CITY OF ALBUQUERQUE

May 16, 2018

RE: Tierra Serena (Glendesto) Subdivision
Revised Grading Plan Stamp Date: 1/23/18
Certification Dated: 5/9/18
Hydrology File: B18D020

Based on your submittal received on 5/10/18, the engineer's certification cannot be accepted for pad certifications until the following are completed:

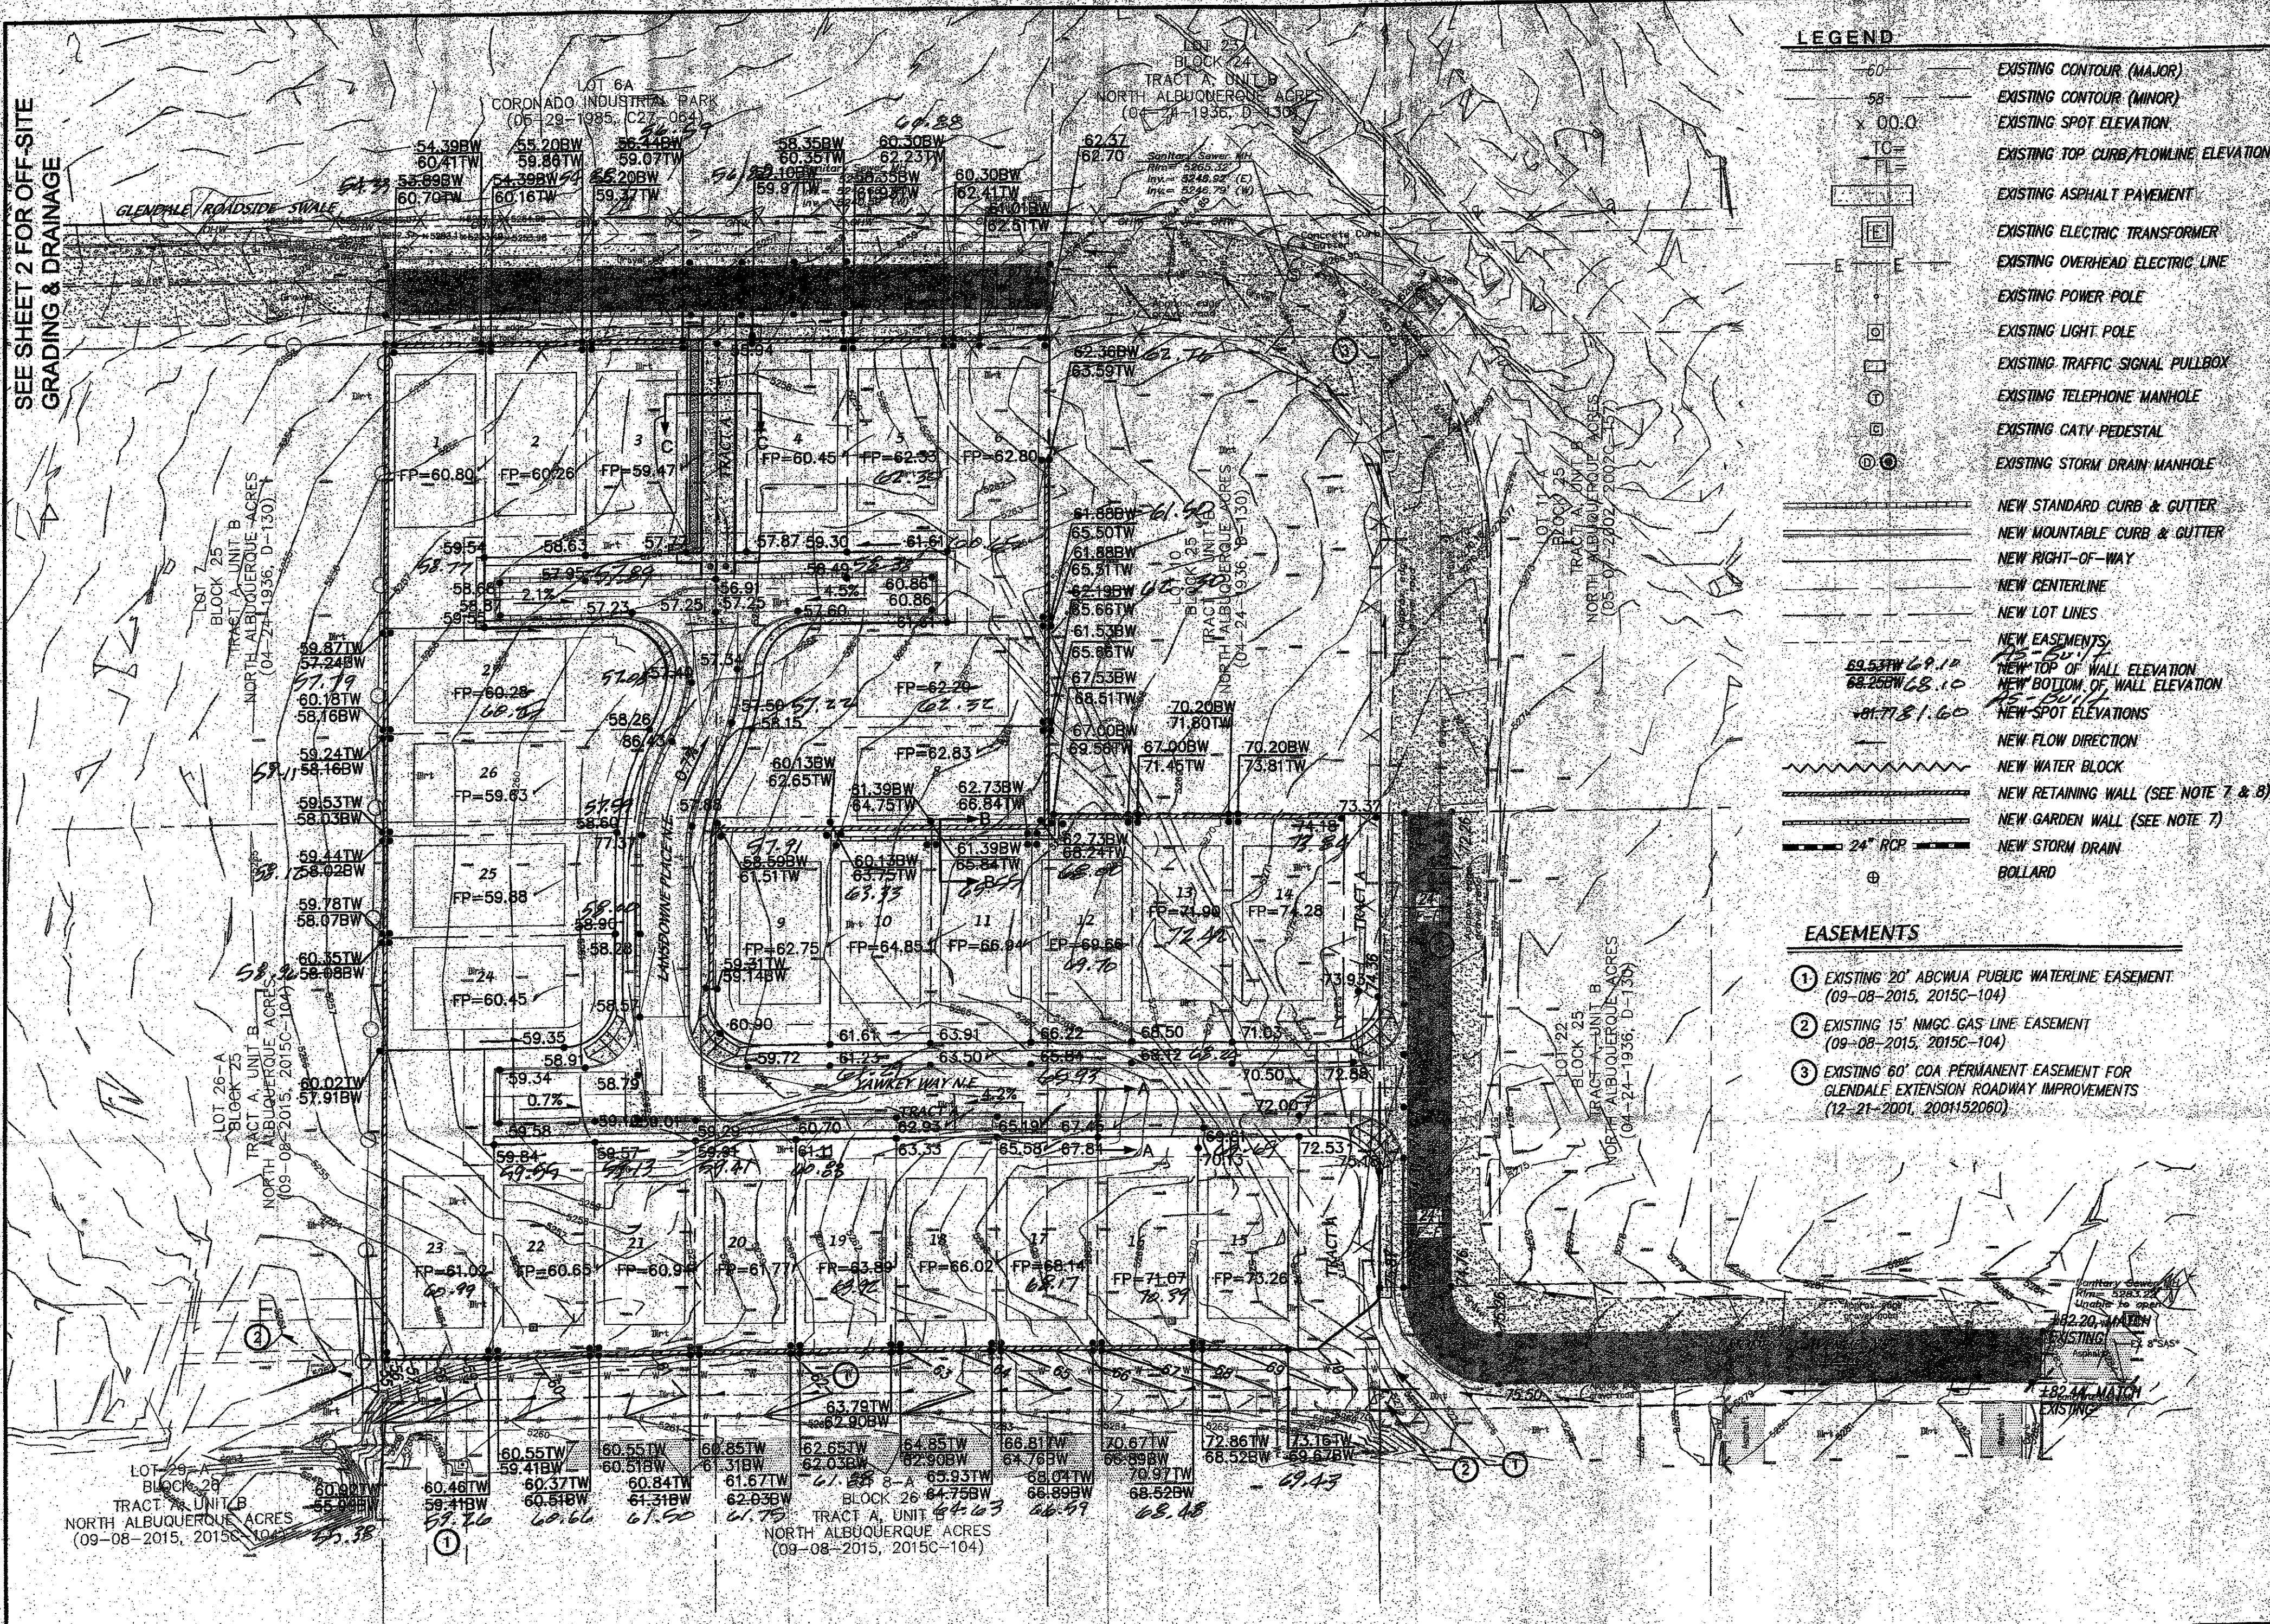
1. The retaining walls need to be completed, backfilled (both sides), and surveyed (top of wall and bottom of wall).
2. For each pad requesting certification: the pad, all 4 lot corners, and the flowline in the street need to be obtained. Additional spot elevations showing flow paths, retaining walls and drainage features need to also be obtained as applicable to the individual lot.
3. The water and gas easement behind lots 15-23 needs to be restored. Fill placed against the wood fence needs to be removed, the flowpath needs to be redefined down the center of the easement, not against either the wood fence or the new retaining wall. This area also needs to be reseeded and stabilized against erosion with check dams and gravel mulch.
4. All other offsite areas distributed as part of this project need to be restored and reseeded as well.
